**Bridge House, Main Street, Wendlebury, OX25
2PW**

21/02208/F

Proposal: Replacement of all single glazed windows on the front of the house and north gable end with new double glazed units; replacement of single glazed porch

Client: William Boucher-Giles
 Drawing: Proposed Plans
 Scale: Varies
 Status: Pre-Application Advice
 Rev: E

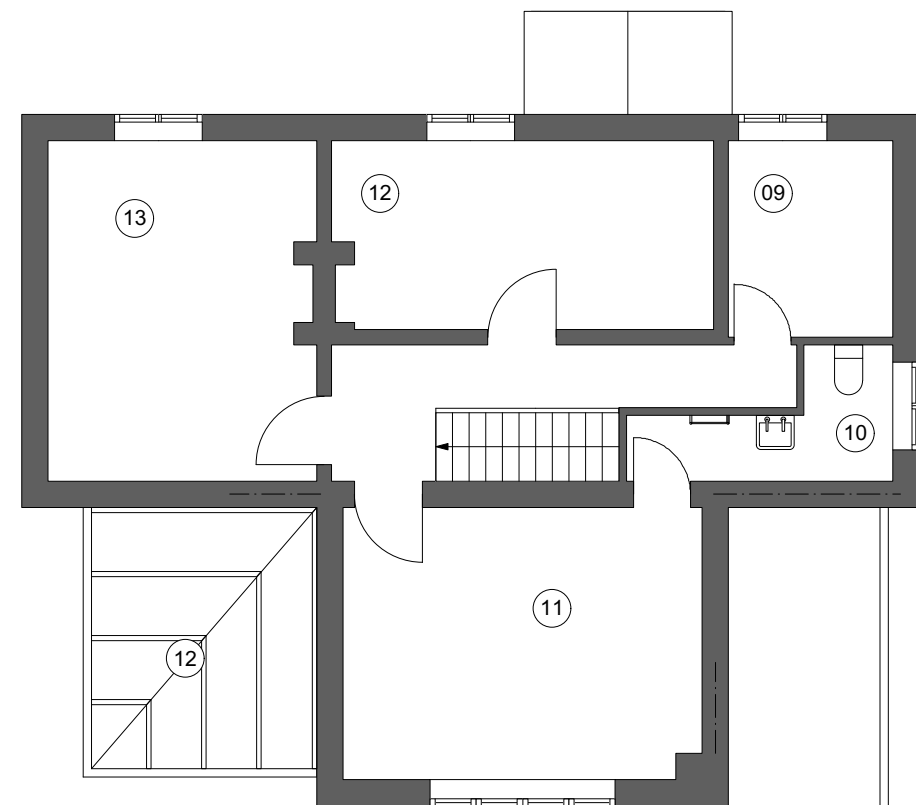
The scale and design of the proposed porch has not been amended following feedback in the pre-application report. However, I would consider that the proposed porch would be a small enhancement to the character of the area and setting of the Grade II listed heritage asset compared with the existing porch. There is evidence of oak framed structures situated immediately adjacent to this dwelling and within the curtilage of the Grade II listed public house. Further, the immediate streetscene is mixed in character and as such I do not consider that the porch element would result in any additional harm to the character of the area than that already posed by the existing dated porch.

Drawing: Proposed Elevations

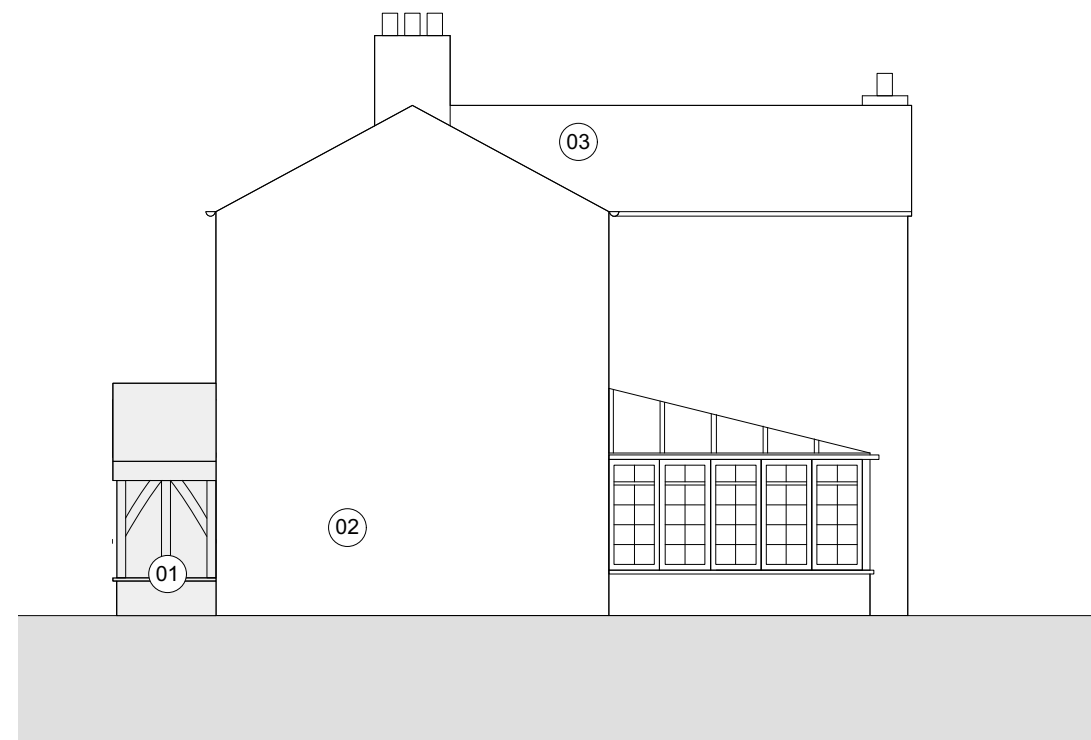
The current windows are modern replacements and are not particularly sensitive to the historic building. There would be no objection to their replacement, but preferably with a more sensitive design. Slim-lite double glazing would be preferable and would provide more traditional profiles to the windows.

There are no objections to the replacement of the porch, which is identified in the Article 4 study as detracting from the character of the building. There would be the opportunity to enhance the character of the property by erecting a porch of more traditional design and dimensions.

The proposals to update the fenestrations would result in a minor enhancement over the existing units. However, no details have been provided, despite the guidance provided in the pre-application report advising that slim-lite double glazing would be preferable. The plans before me indicate that the proposed fenestration would reflect the existing fenestration and overall would be visually sensitive.

3. The natural stone to be used on the walls of the porch shall be of the same type, texture, colour and appearance as the stone on the existing building and shall be laid dressed, coursed and pointed to match that of the existing building.
